**RE: Letter of Intent  
Proposed Silverado Ranch Metropolitan District (the "District")**

This correspondence is to serve as a letter of intent for the formation of Title 32 metropolitan district to serve the Silver Ranch Subdivision consisting of 320 acres planned for 64 residential units on 2 1/2 acre lots.

# LOI V\_1 redlines.pdf Markup Summary 10-12-2021

VICINITY MAP
SILVERADO RANCH
METRO DISTRICT
N1/2 SEC. 16, T15S, R63W 6th P.M.

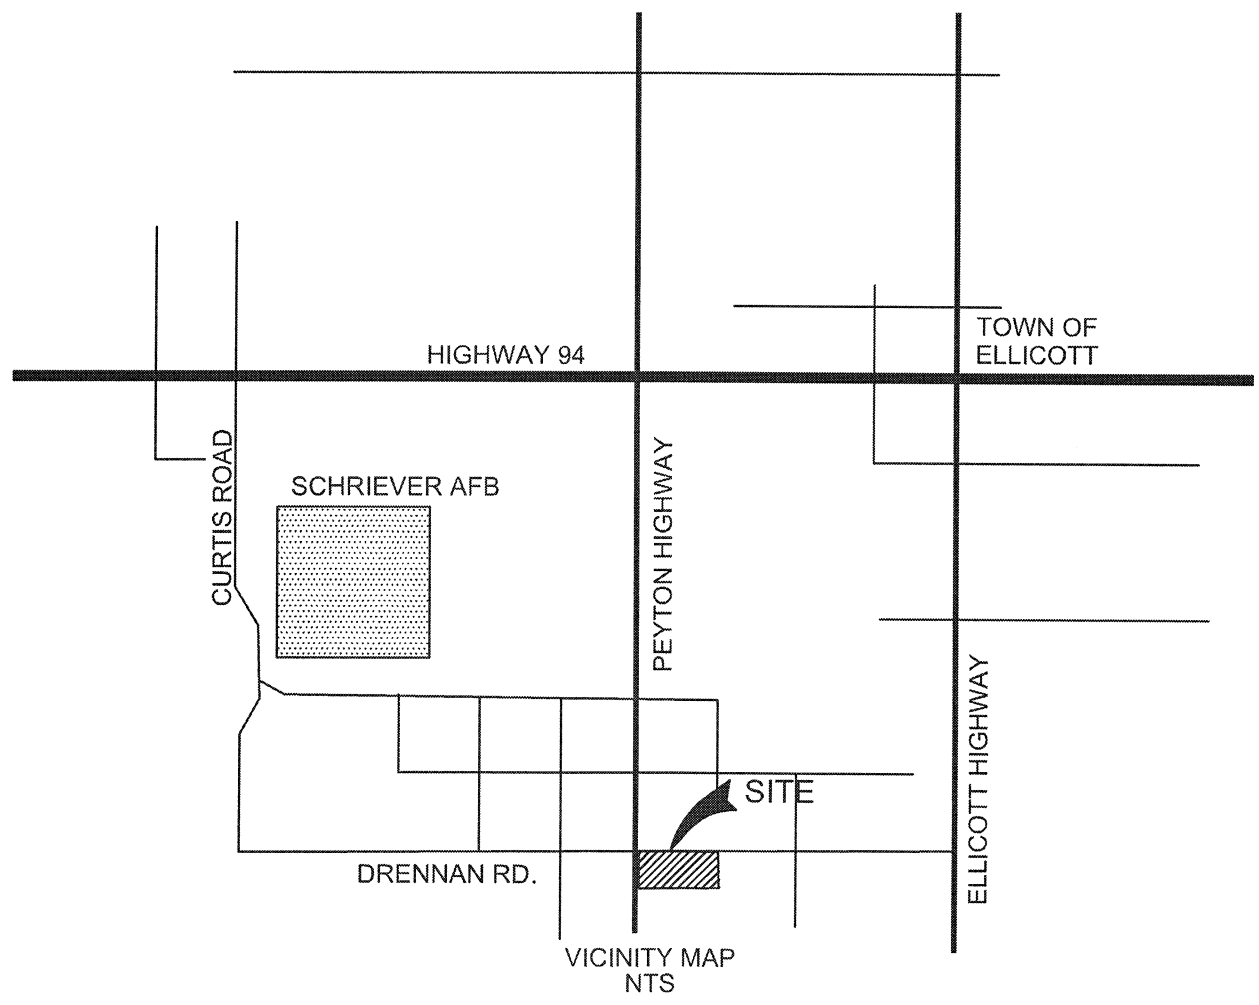
what is the acreage of the district without the lots? what is the acreage of the future inclusion areas- provide legal for the future inclusion areas.

# DISTRICT BOUNDARY MAP EXCLUDING LOTS 1, 2, 3, 5, AND 8

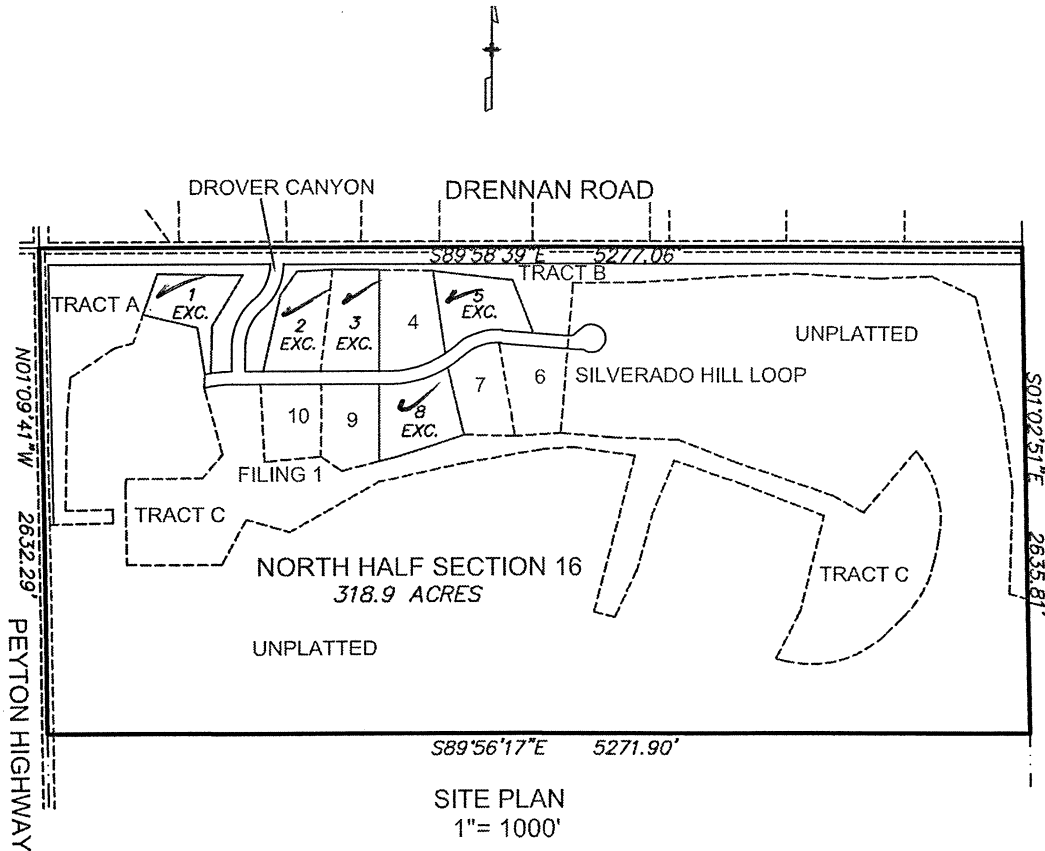
what is the acreage of the district without the lots? what is the acreage of the future inclusion areas? provide legal for the future inclusion areas.
